CITY OF PORTLAND

February 26, 2004

RE: Yale Street Subdivision, Lots 2, 4, and 5

TITLE:
LOT 3
UNIVERSITY PARK
YALE STREET
BUILDING SITE LAYOUT

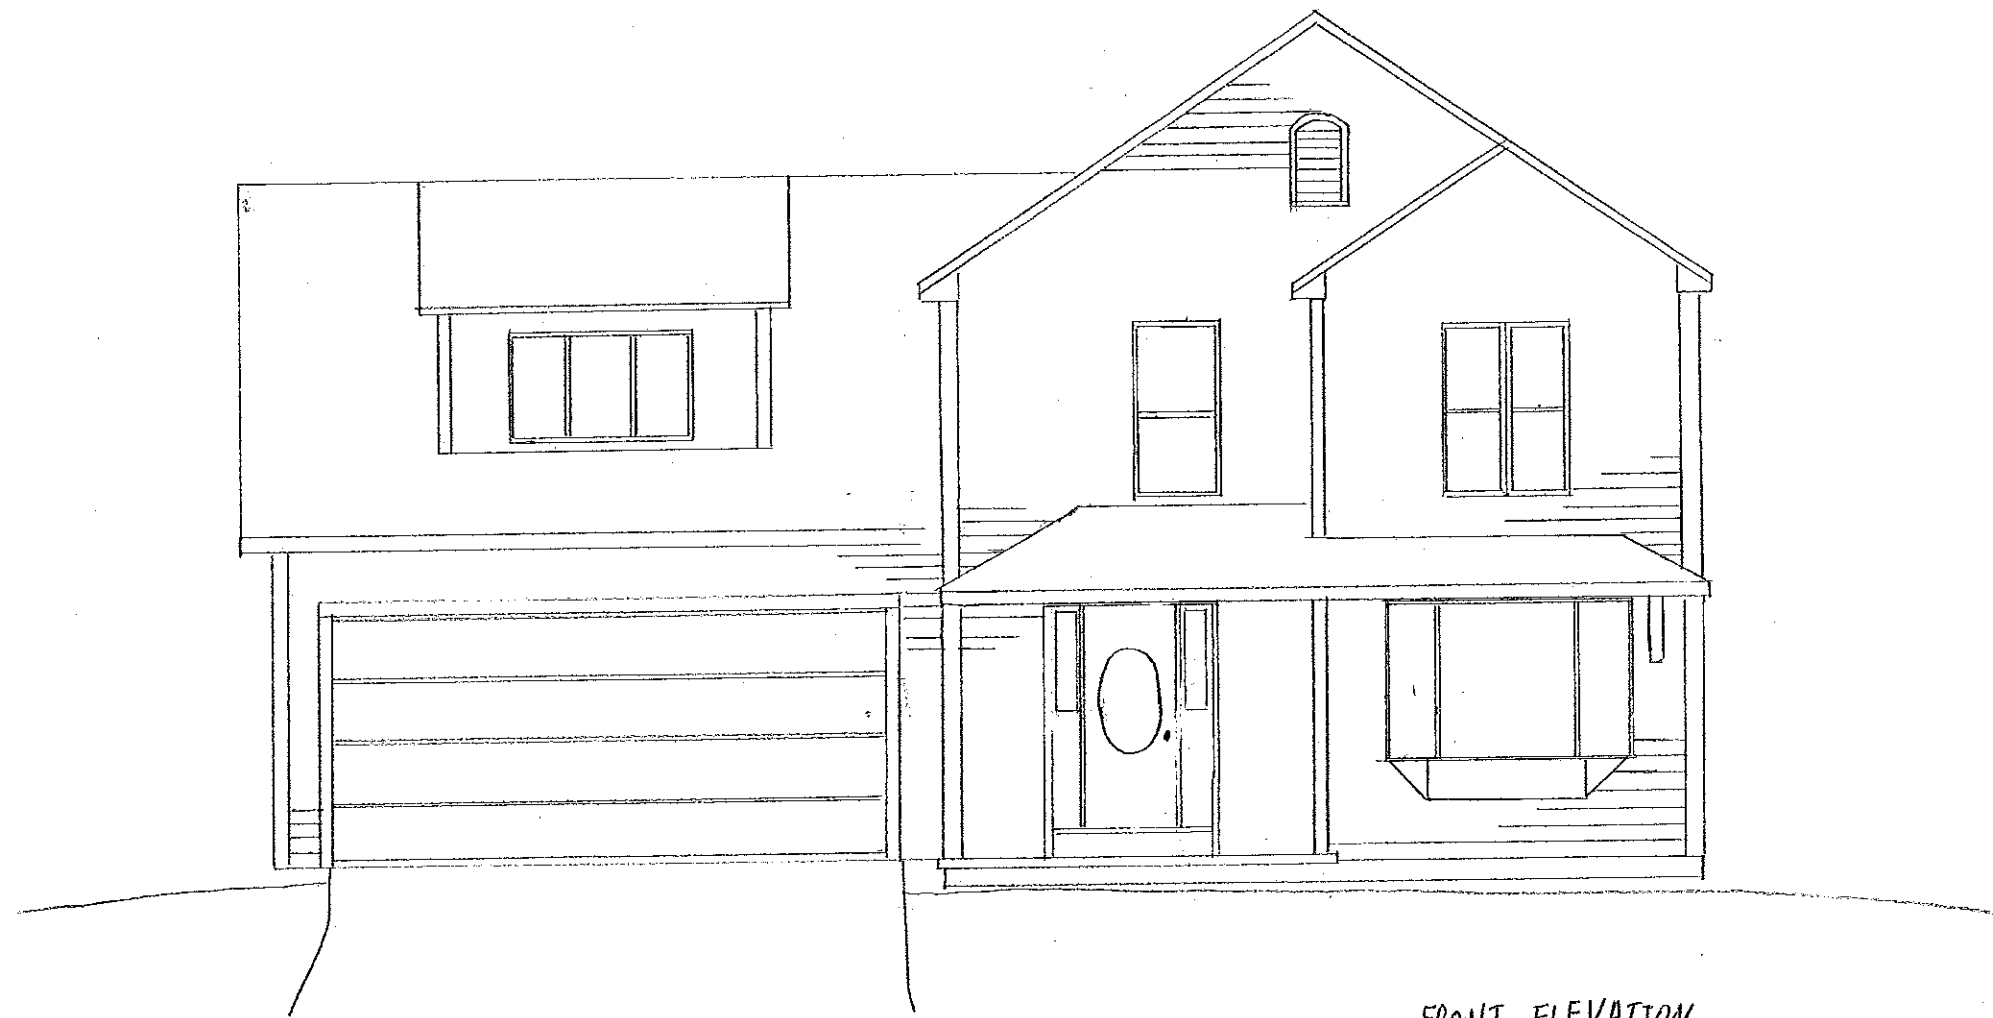
After meeting on site to look at the buildout of lots 2 and 5 of the Yale Street Subdivision, it was noticed that the buildout does not match the approved site plans. As discussed, the daylight basement features on lots 2 and 5 are not indicated on the site plan. As a result, the approved grading plans are not being constructed as proposed.

At this time, the City requests that you apply for a minor site plan amendment to the Yale Street Subdivision plan. In particular, this amendment should show new/proposed topography and a revision to sheet #9 (grading and drainage) is requested. Also, we had met previously to discuss the swale behind the lots and the effort to conserve some of the existing trees. Tree preservation may make it difficult, or perhaps impossible, to construct the swale. Please address this within your amendment.

Currently lot 4's building permit application shows the same, building plans that do not match the grading/site plan. As I understand, you will be re-submitting to address this lot as well.
